Proposed Solar Farm and Bess Facility, Bardling's Drove, Sutton St. James, Spalding

Highways Technical Note

Response to Highways Comments from Lincolnshire County Council

21st February 2025

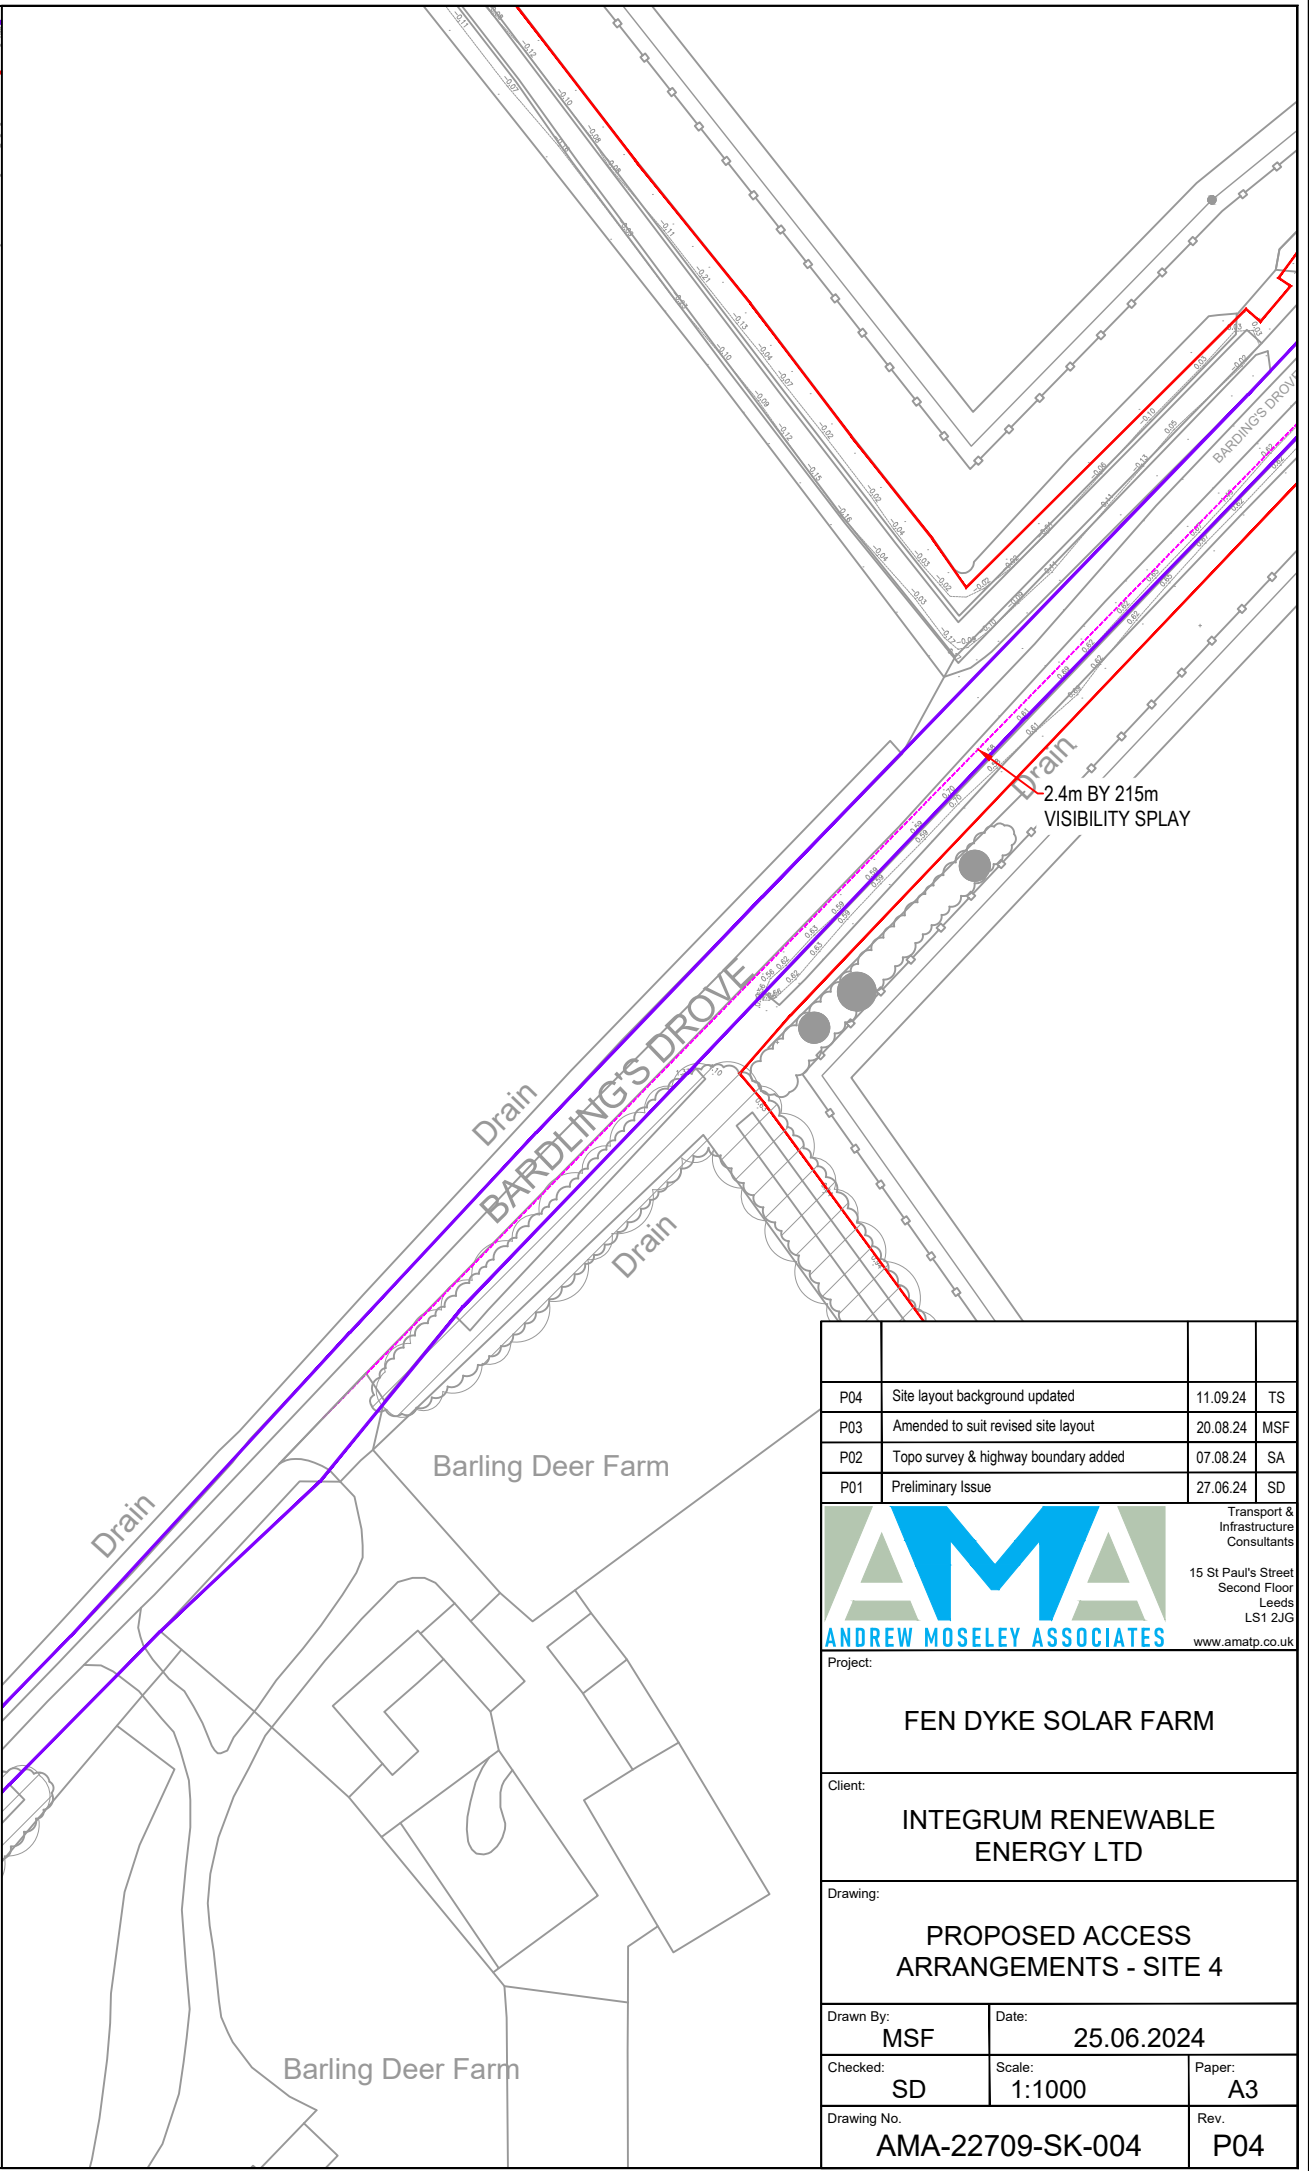
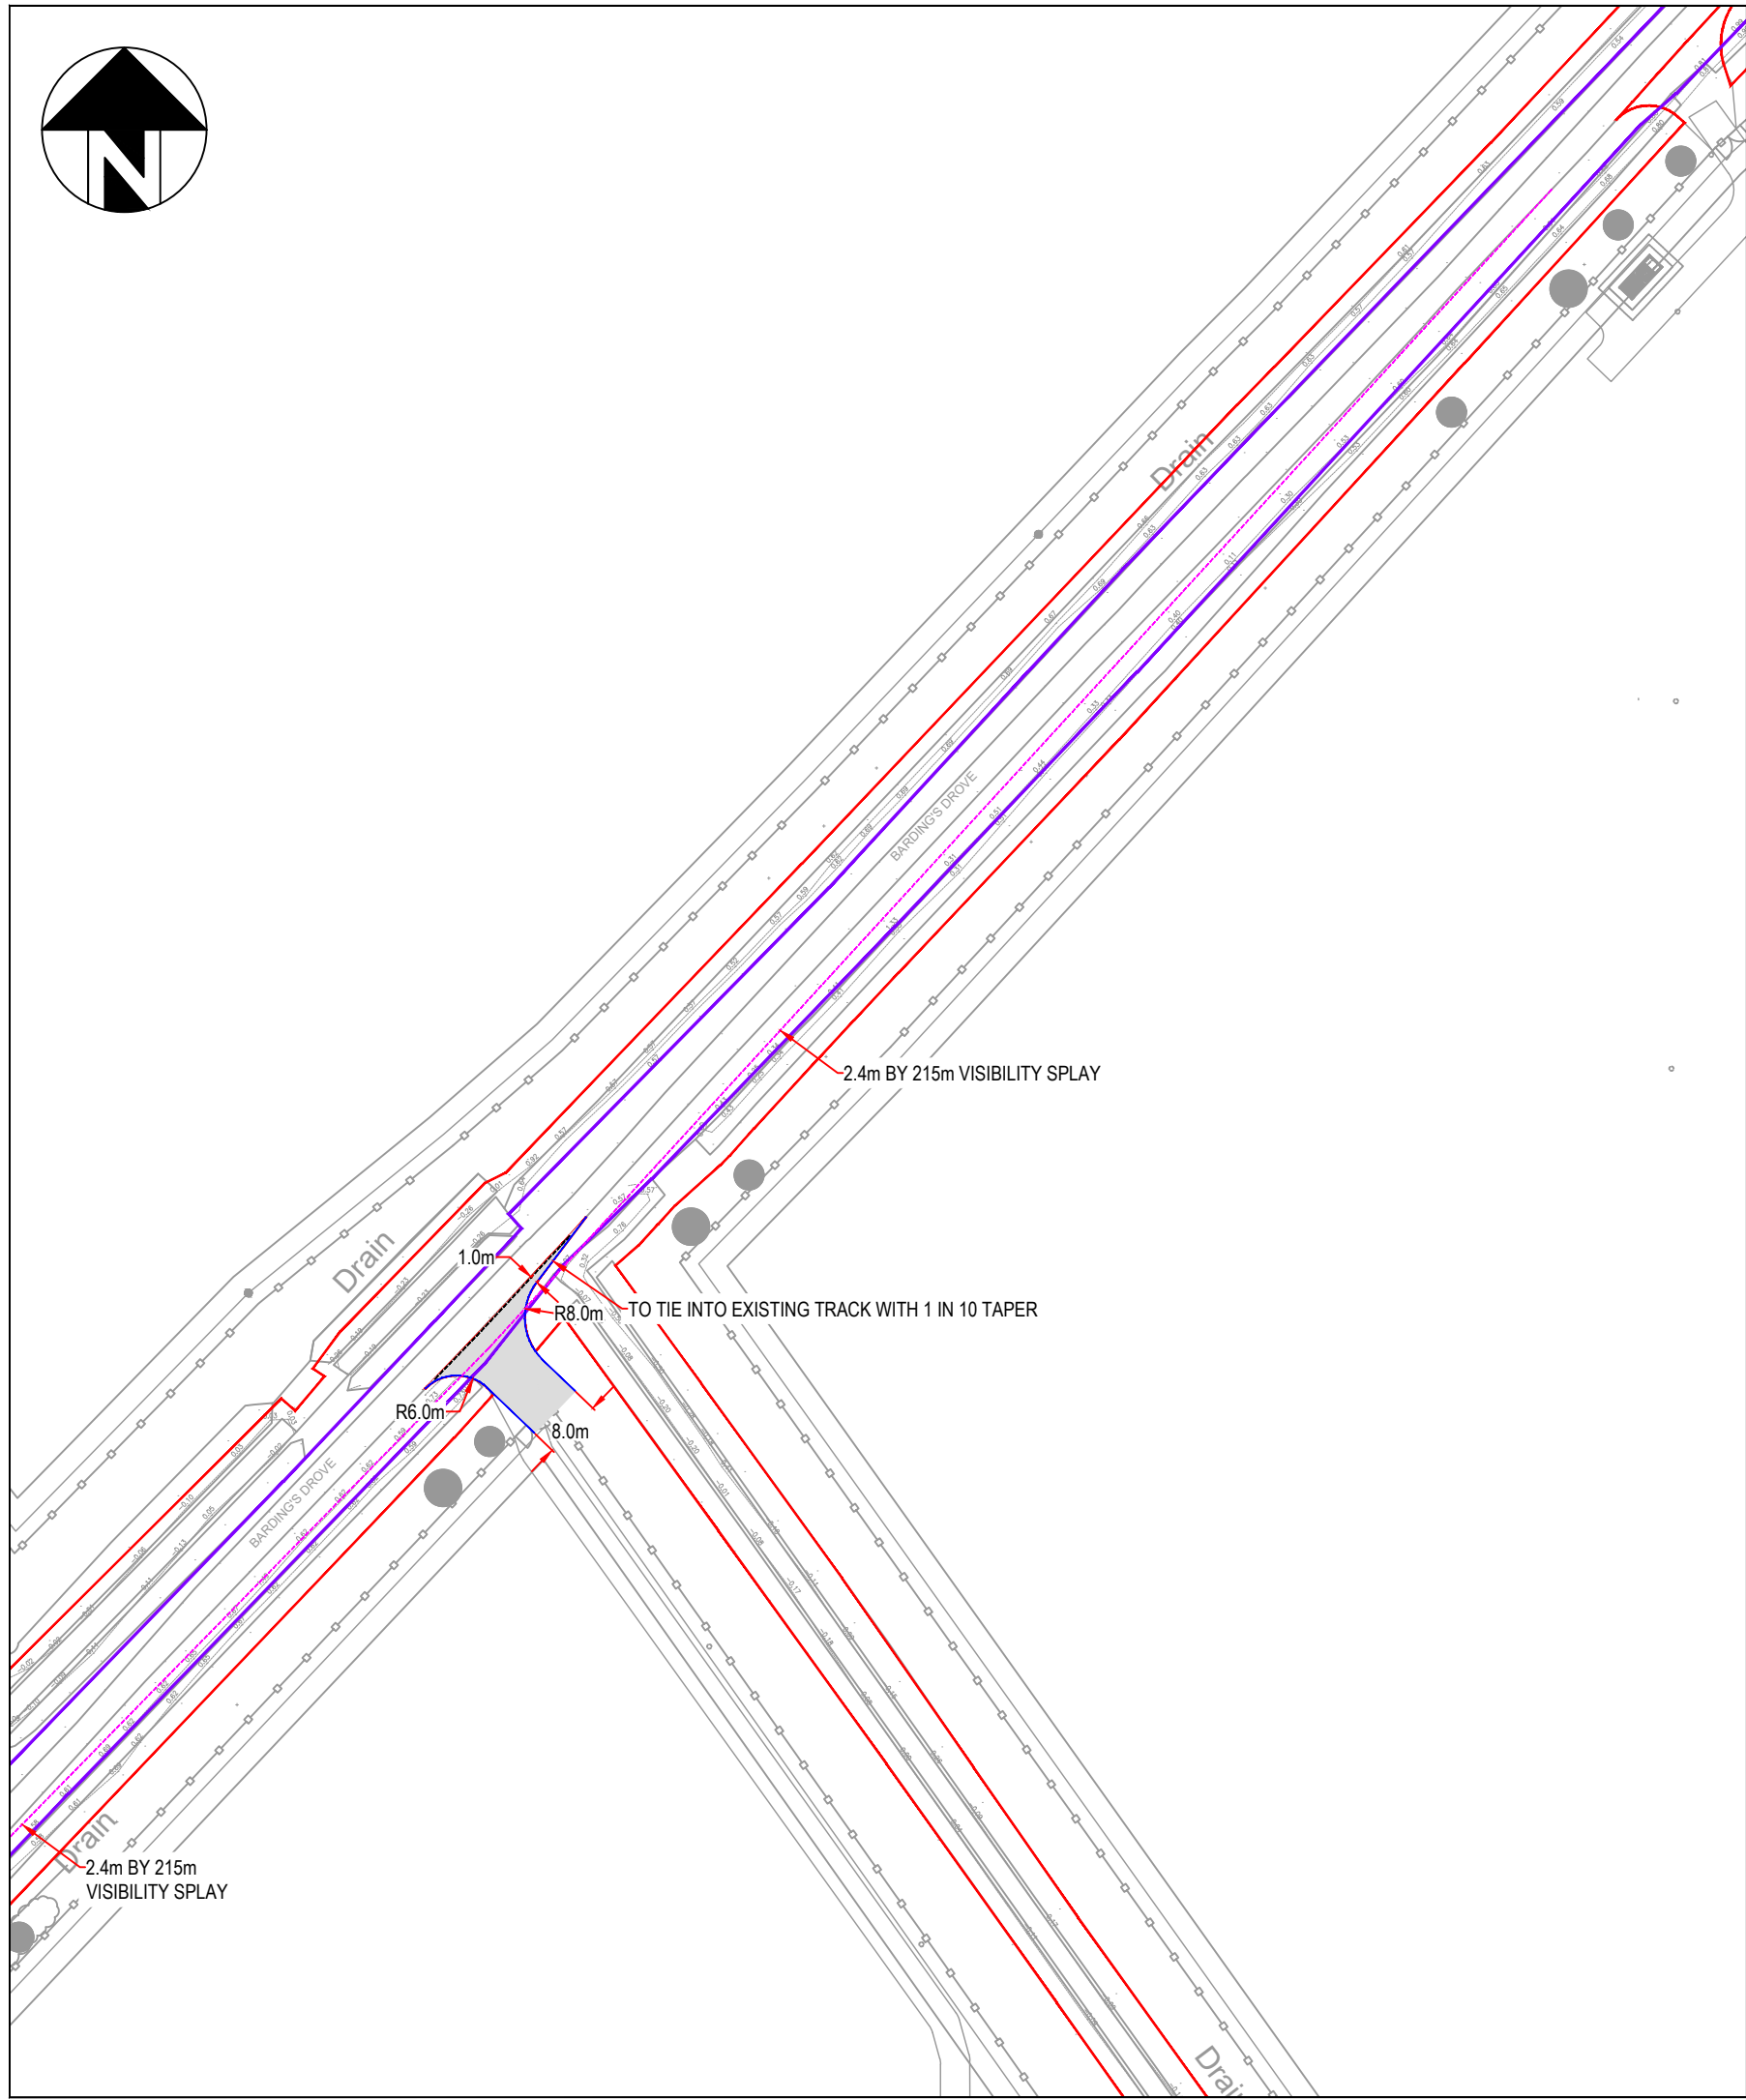
Visibility has been demonstrated in accordance with DMRB this is not necessary – they should be measured in accordance with Manual for Streets.

Detailed access drawings are required with swept path drawings detailing the largest size vehicle that will be accessing the sites.

Whilst this response is open ended, AMA have taken into account LCC's views regarding the rural and lightly trafficked nature of these roads and therefore consider the provision of visibility splays in line with Manual for Streets (MfS) for a 30mph road appropriate. All visibility splays have been updated as requested and these can be viewed at [Appendix C](#).

AMA can confirm all construction accesses will be constructed in accordance with LCC specification, and AMA's preliminary drawings have been updated to reflect this. Please see [Appendix C](#).
